Supplementary Plan pls. upload.

WA/7/19/RES - Lanes End, West Walberton Lane - Additional information request

PJ DEVELOPMENTS LTD 2 Square Chambers 23 High Street Emsworth PO10 7AQ Tel: 0843 289 3430 Email: enquiries@pjdevelopmentsltd.com	
PROJECT: FORMER LANES END	
SITE PLAN OUTLINE PLANNING APPLICATION	
DATE: JANUARY 2019	DWG. NO 19-001 PL02
SCALE @ A1: 1:200	
REV: C

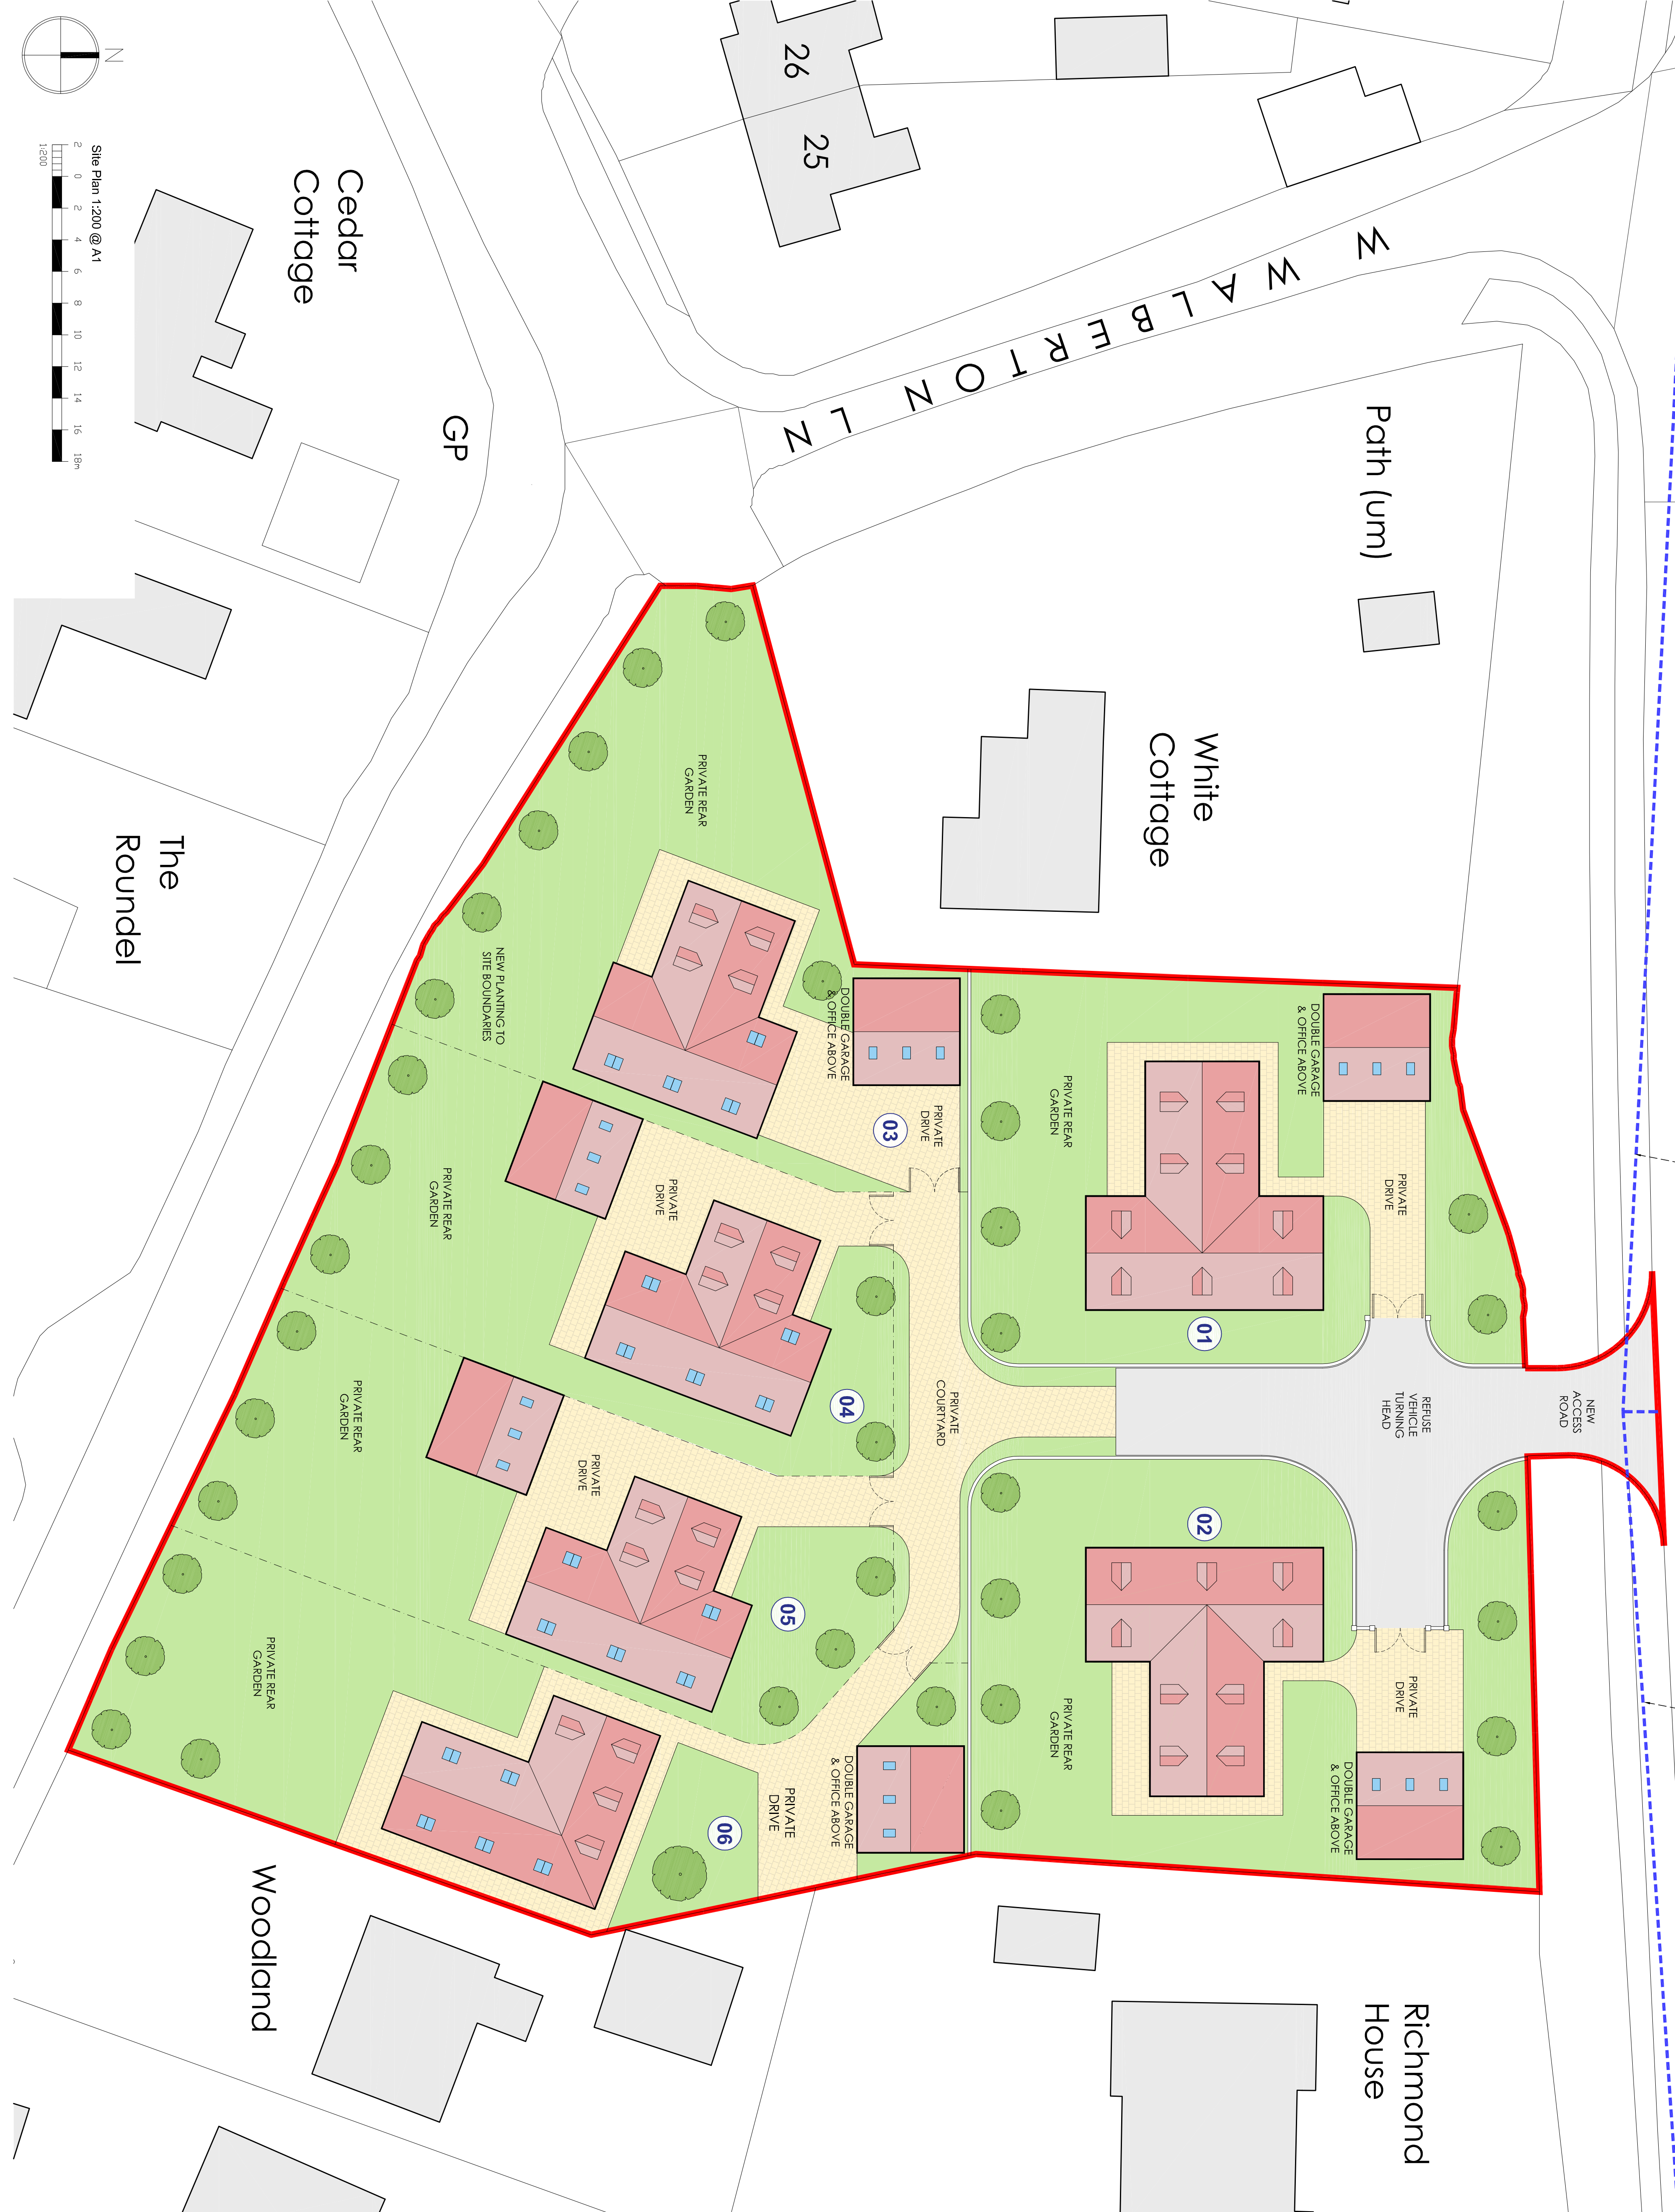
Highways - The applicant should clarify whether refuse collection will be from the roadside or within the site and demonstrate via swept path tracking that a fire appliance can enter and turn on site. The Fire appliance is required to reach within 45m of the furthest point of each building which does not currently appear to be the case.

1. Amend the layout to ensure that a minimum of 9 metres exists on from blank gable end (or obscure glazed windows non opening below 1.7 metres in height) of nearest proposed house to gable end of 'Woodlands' which currently incorporates sole habitable room windows.
2. Remove second storey of houses/rooms in roof. 3 storey townhouses would not be acceptable in this location

1, Happy to amend property six to make a nine metre distance.
